Marine
Management
Organisation

Planning Inspectorate reference:
MMO reference: DCO/2013/00010

11 February 2021

Non-Material Change Application to the Dogger Bank Creyke Back Offshore Wind Farm Development Consent Order 2015 (as amended)

Title: Predicted Noise Contours and Impact Ranges for Fleeting and Stationary Fish at the Dogger Bank A & B Wind Farms, Location ID6

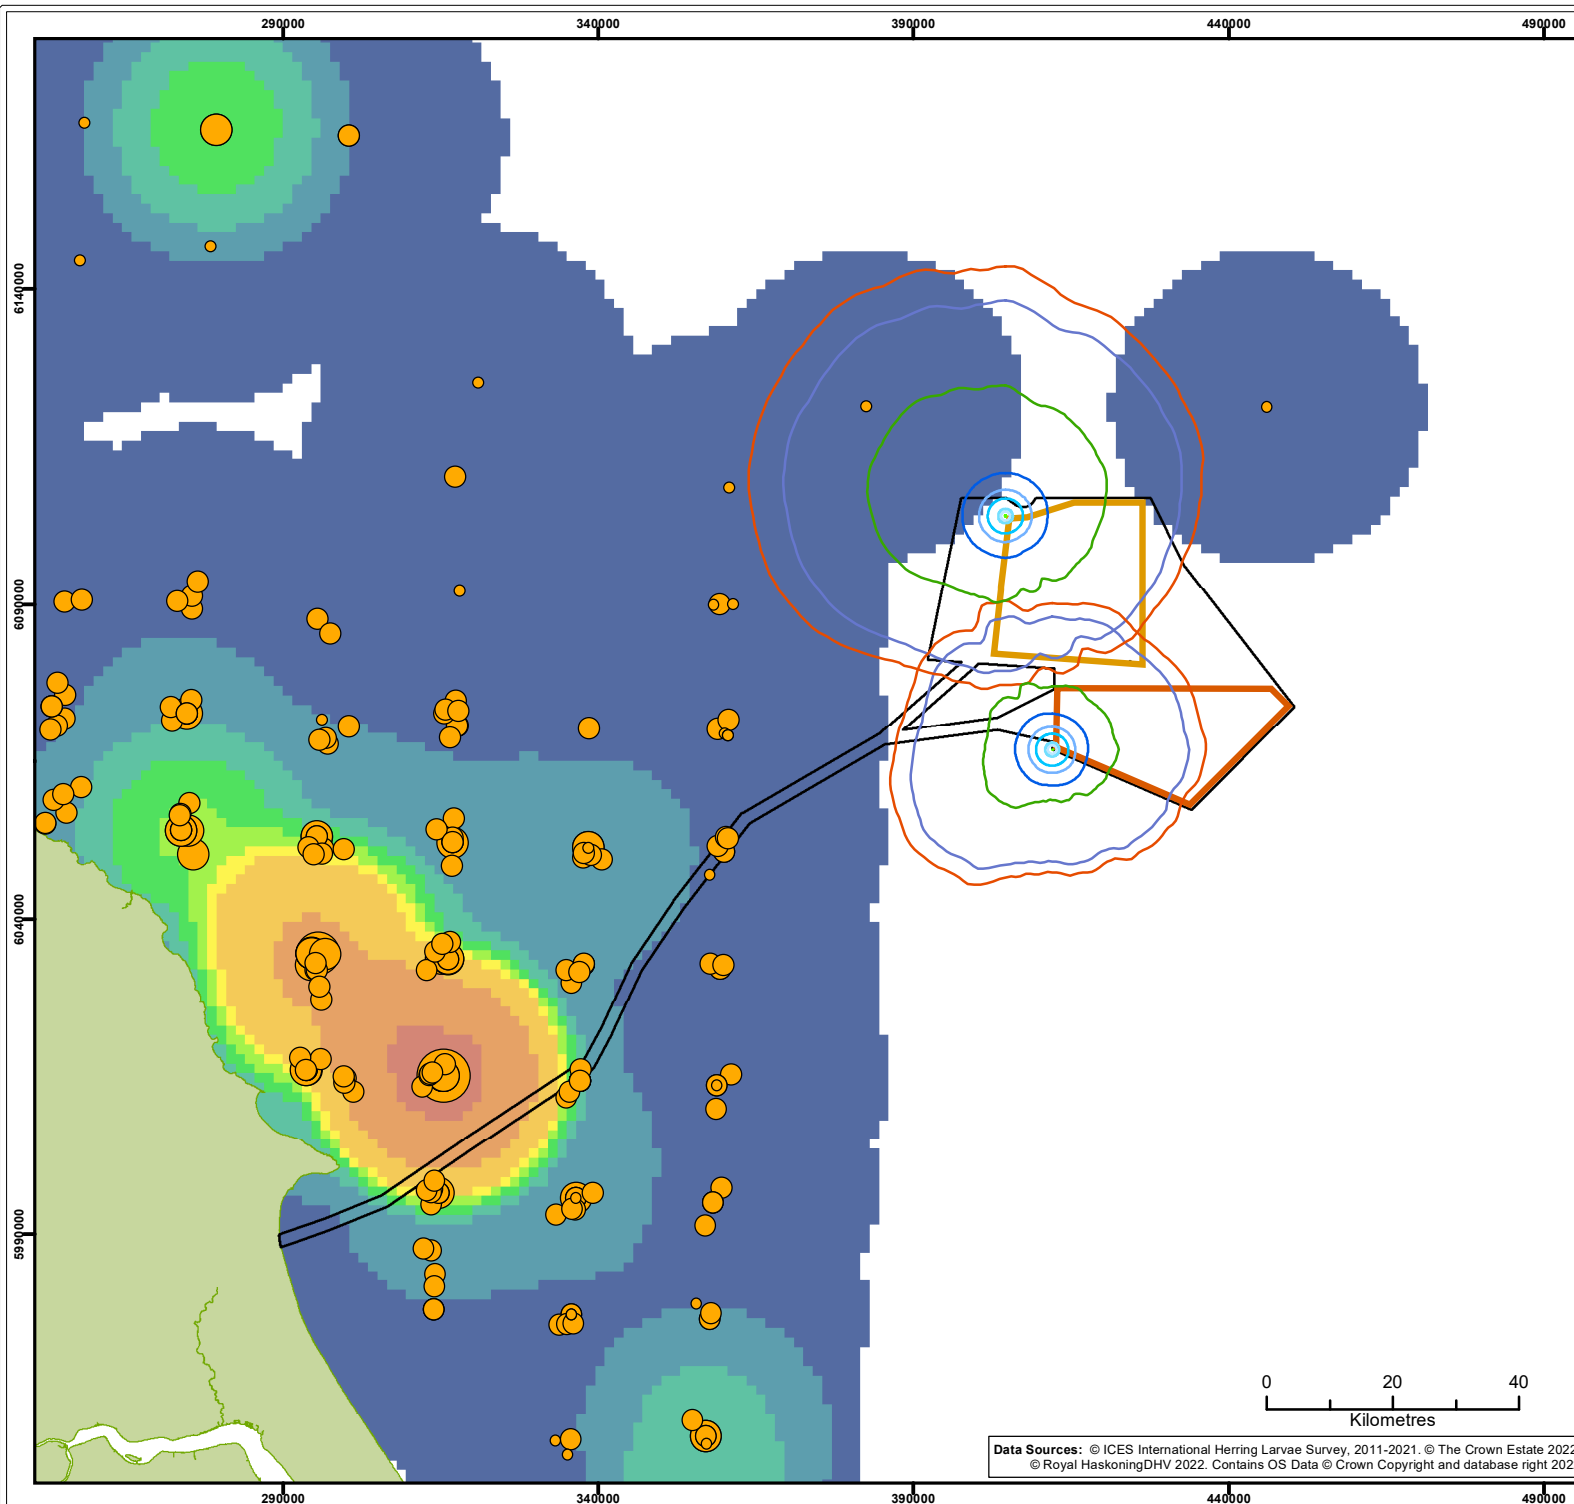
2. The Applicant has stated that the Projects are located '*approximately 80km from the high-density spawning grounds*' for Herring, however, it is unclear what data or maps have been used to support a distance of 80km and no supporting information has been provided to contextualise the definition of '*high-density*'. Herring do not exhibit spawning site fidelity and the locations of Herring spawning activity are known to vary year on year (see Annex 1 for ICES plots which demonstrate this point), therefore the distance between the Banks Herring spawning ground and the project will also vary inter-annually. The MMO would have expected the Applicant to have used International Herring Larval Survey (IHLS) data to support their assessment, for example, by providing a visual representation of Herring larval densities for the Banks Herring stock over a 10-year period, typically the data are presented in the form of a 'heat map'. The heatmap can then be overlaid with the piling noise contours from the modelling, to show the range of effect from noise in relation to larval densities. IHLS data can be downloaded from [Eggs and larvae \(ices.dk\)](http://ices.dk).

3. The MMO considers that the Applicant should also undertake noise modelling for the received levels of the Single Strike Sound exposure levels (SEL_{ss}) at the Herring spawning grounds based on 135dB. The use of the 135dB is based on startle responses observed in sprat by Hawkins *et al.* (2014). Sprat is considered a suitable proxy species for Herring for the purpose of modelling likely behavioural responses in gravid Herring at the spawning ground. It would be useful if the 135dB noise contour was presented in mapped form, i.e., as an additional contour (additional to the 186dB, 203dB and 207dB that have already been modelled).
